# DRB CASE ACTION LOG (SITE PLAN B.P.)

DRB Application No.: 04DRB-01094 (SBP)  
Project Name: NO. ALBUQ. ACRES UNIT B  
Agent: Dorman Breen Architects

**CITY OF ALBUQUERQUE  
PLANNING DEPARTMENT  
July 21, 2004  
Development Review Board  
Comments**

**RE: Albuquerque Sign Print/SPBP**

TYPICAL PLAN
SCALE 1/4"=1'-0"

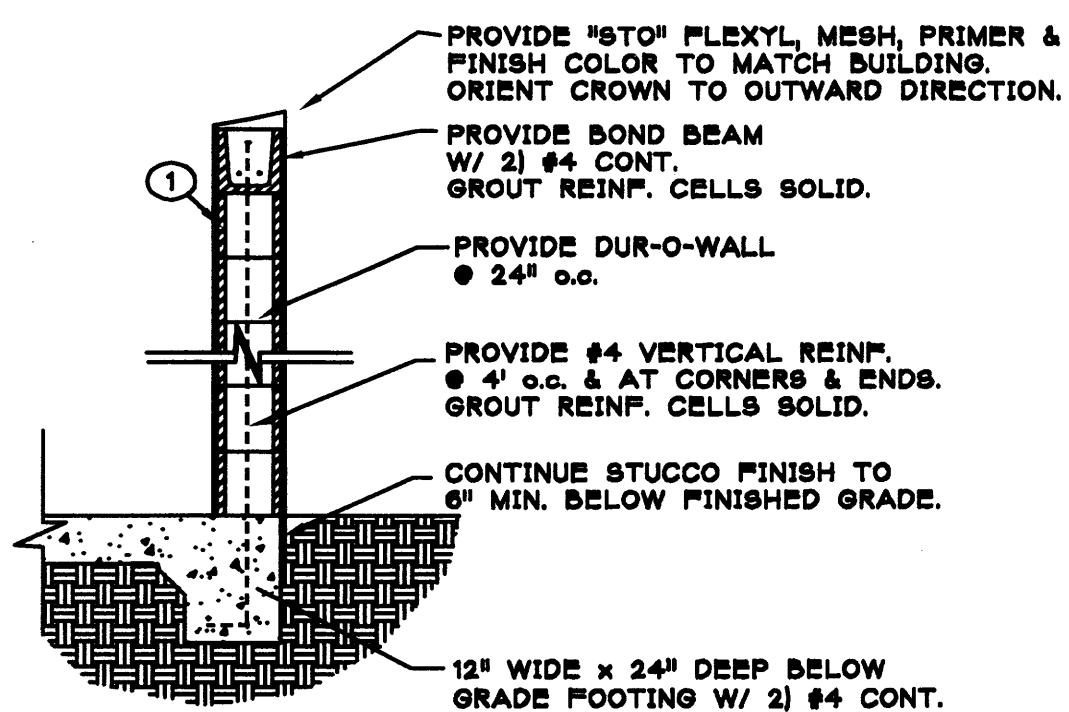
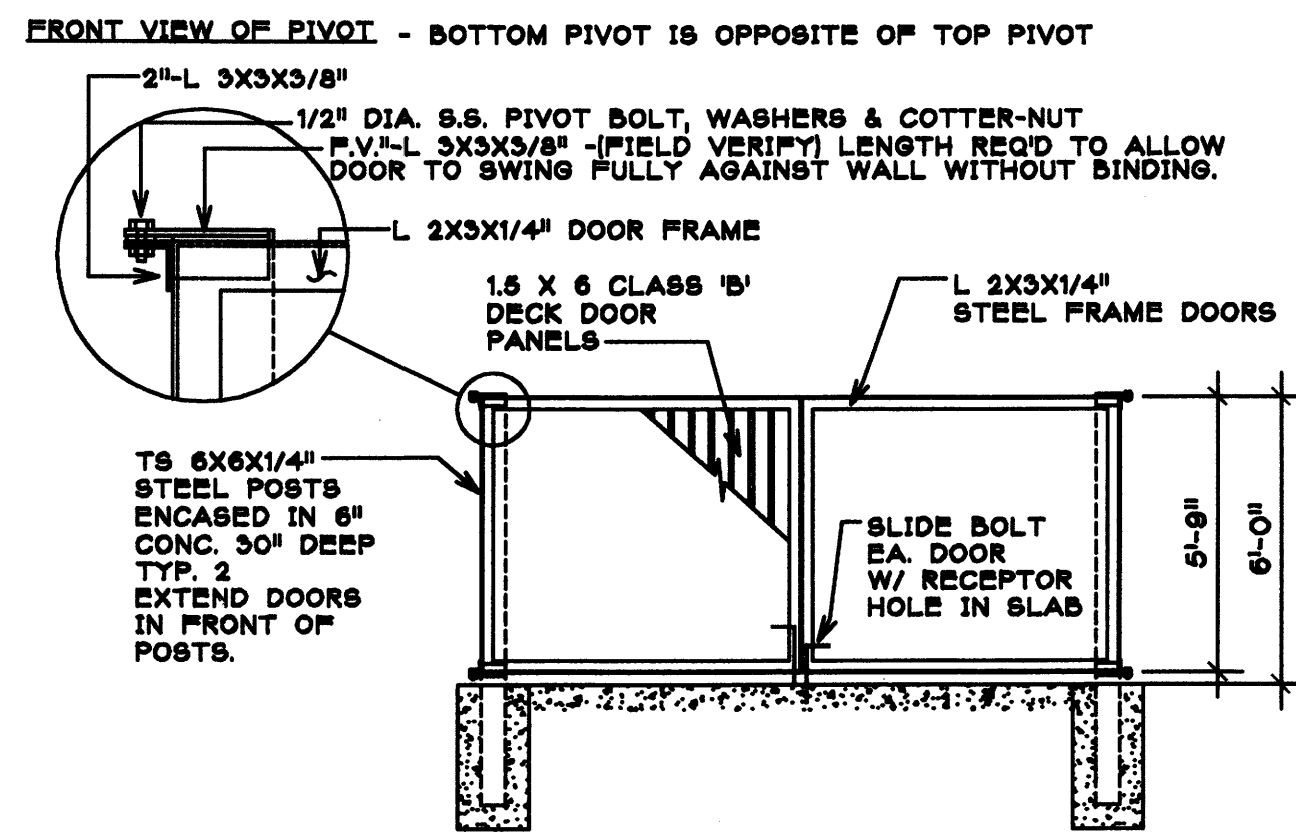
10. The trash enclosure elevation is missing.
11. Please remove the junipers from the Landscape Plan.

SITE DEVELOPMENT PLAN for BUILDING PERMIT

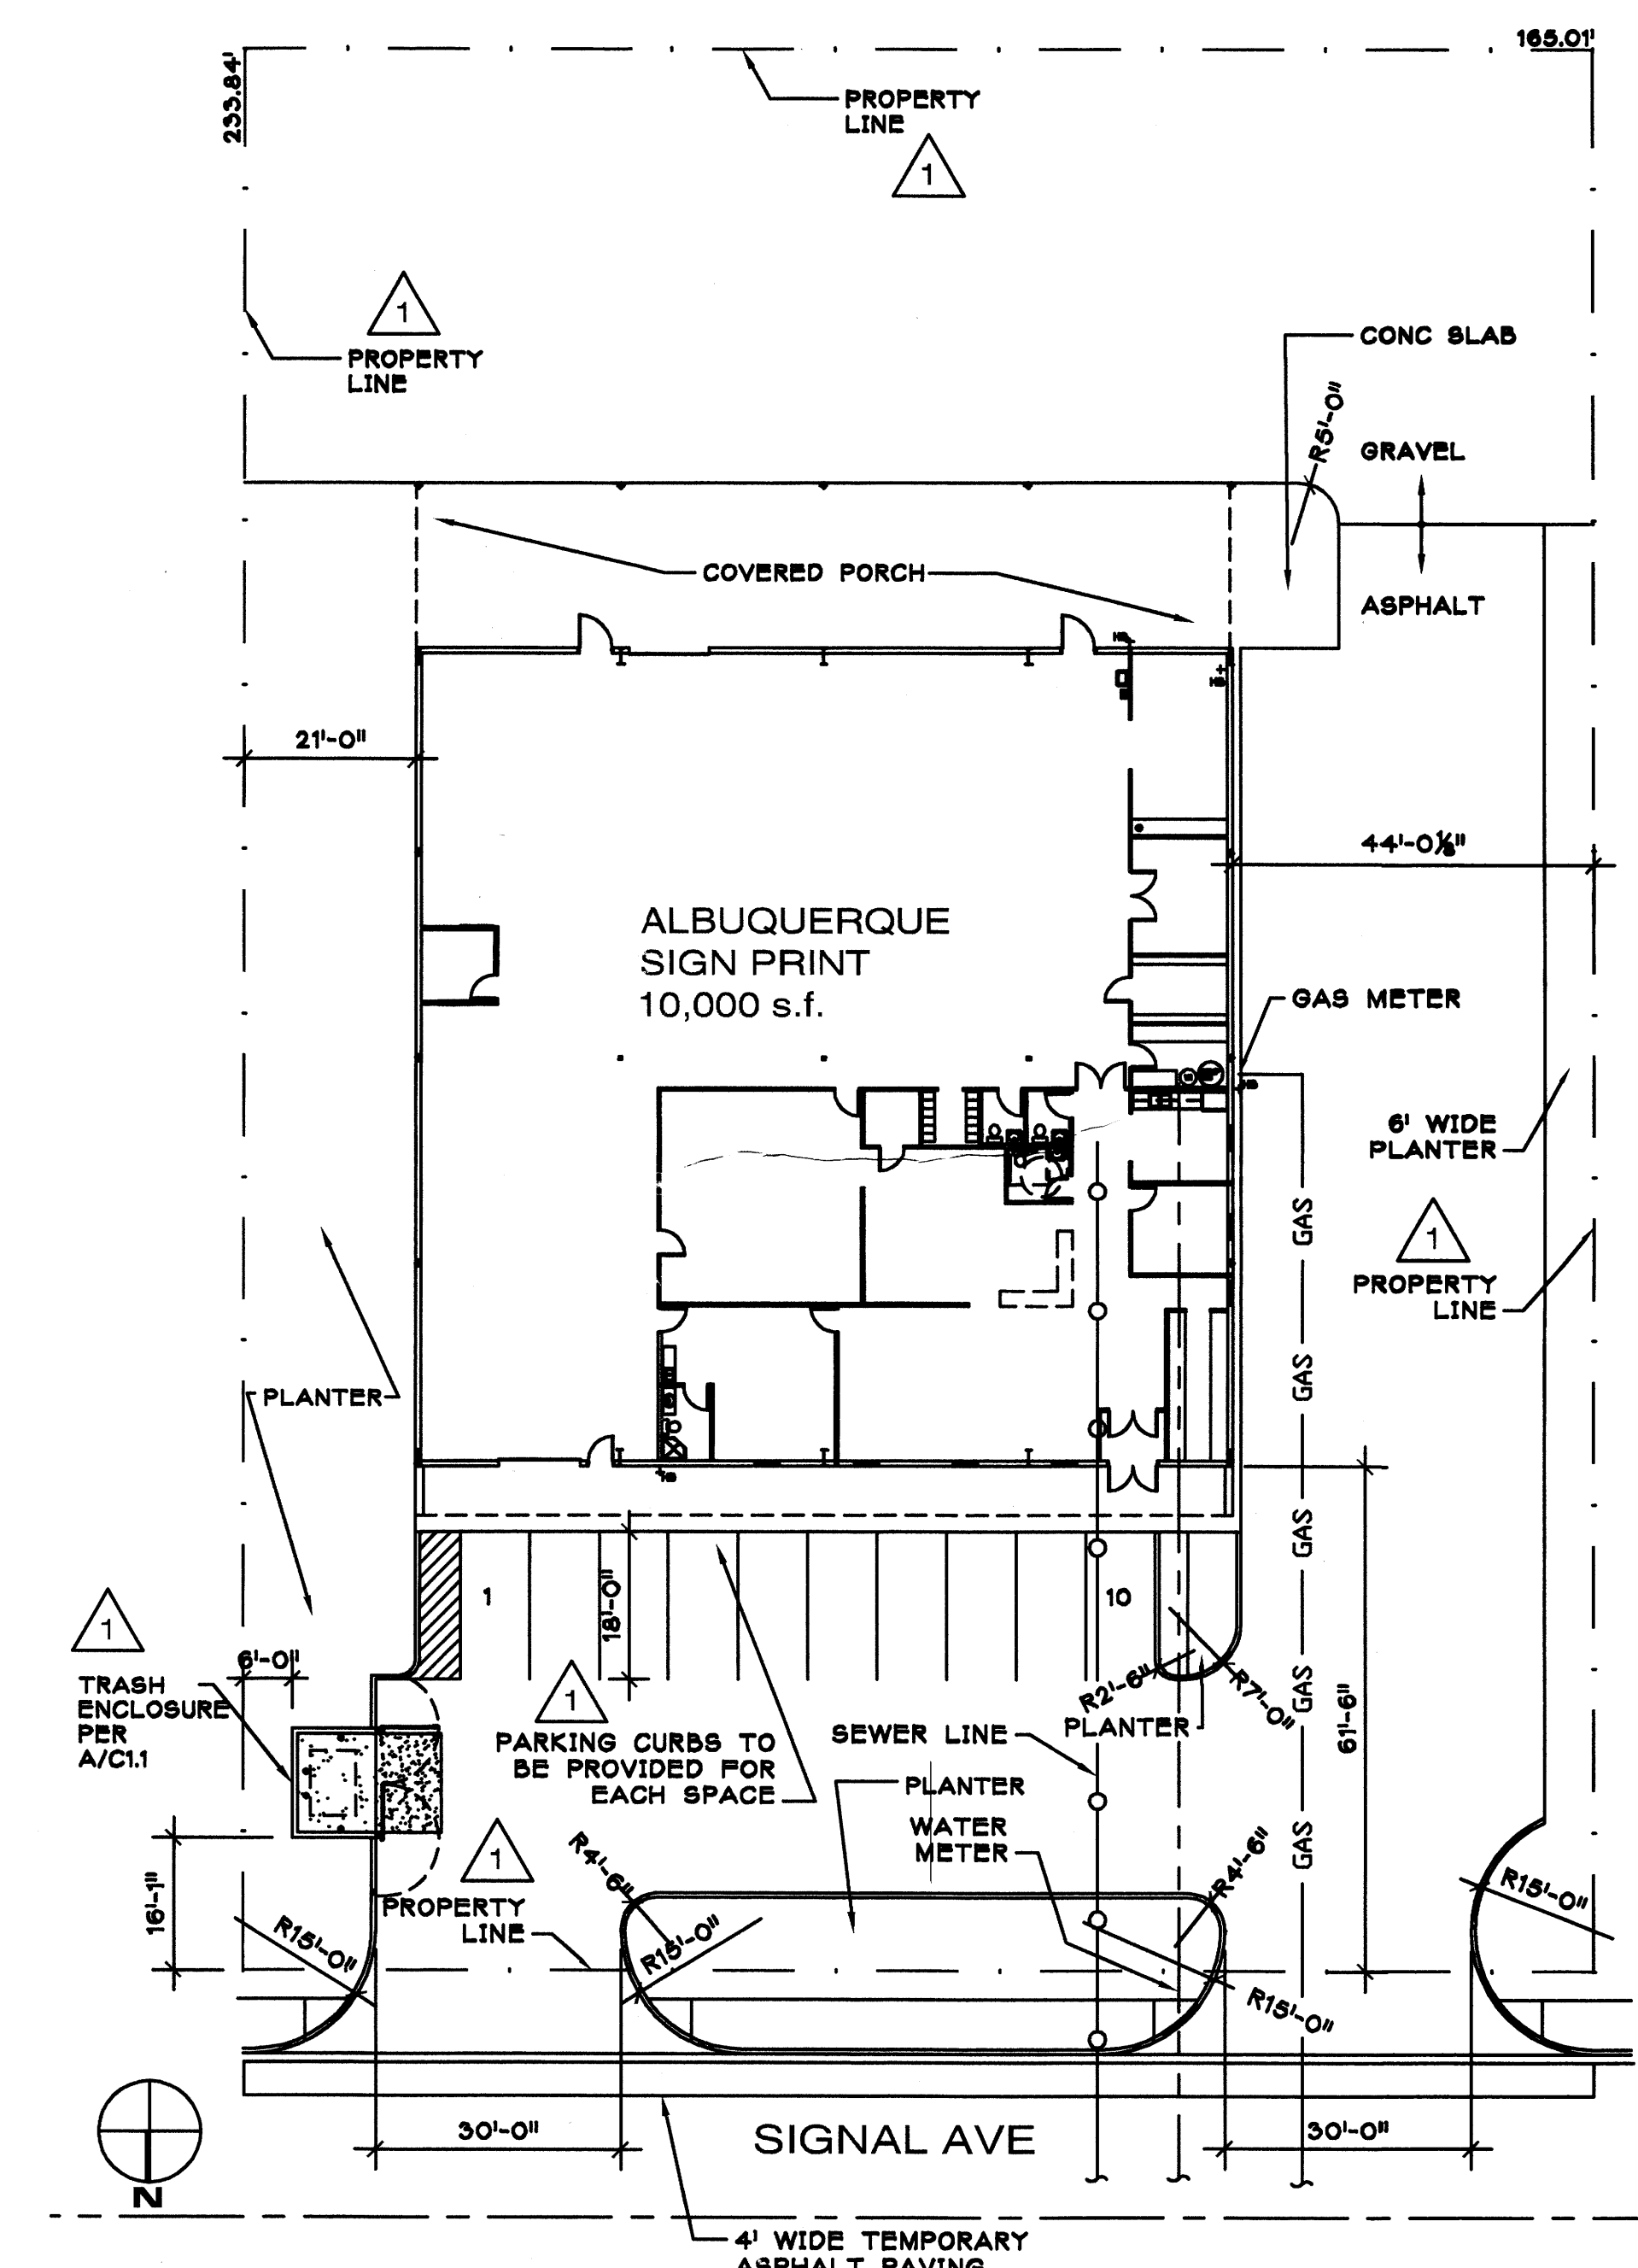
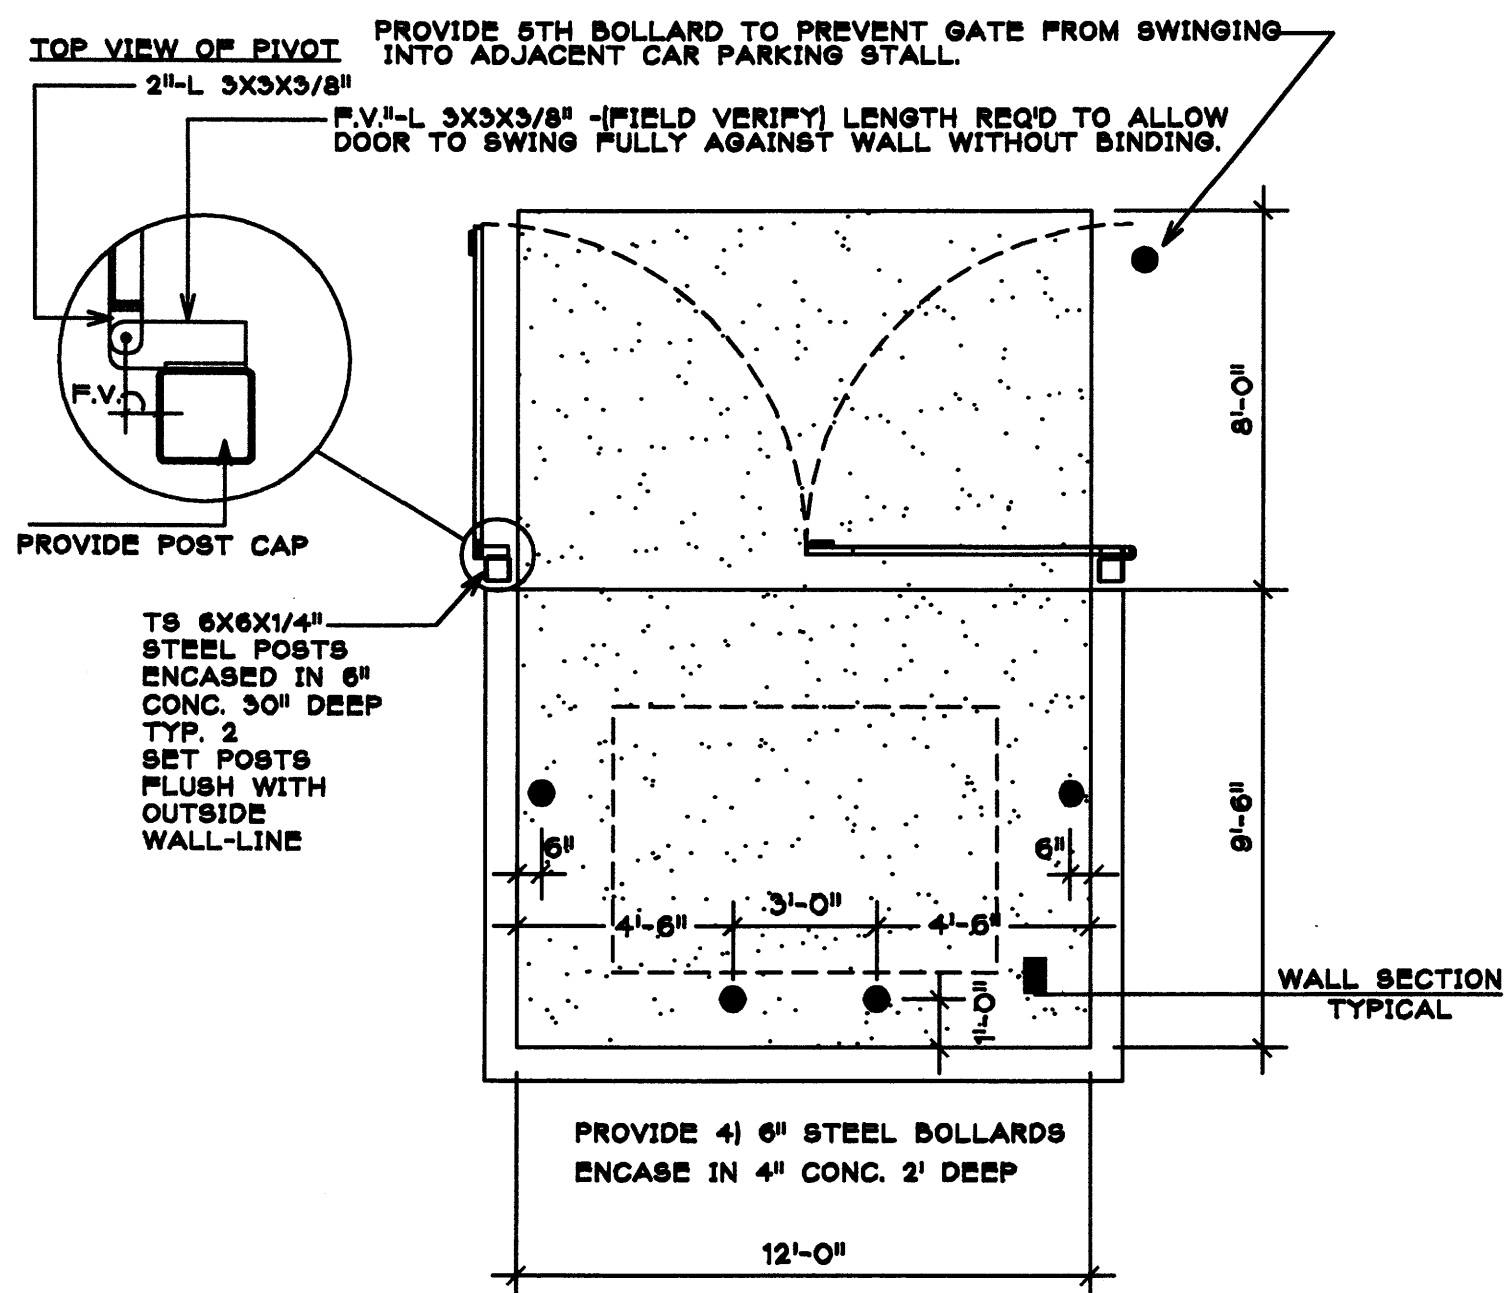
1. The sheet title for the site plan should read "Site Development Plan for Building Permit".
2. If the parking spaces are only 18 feet deep, a note is needed indicating parking curbs will be used to prevent vehicular overhang onto the sidewalk.

6. Please include the standard language on the landscape plan. A copy is attached to these comments.
7. The property lines are not clearly identified. Use a bold line & identify.

8. Are there any walls or fences planned for this property along the abutting streets?
9. The zone atlas page used as the site location map is missing from the Grading & Drainage Plan page.
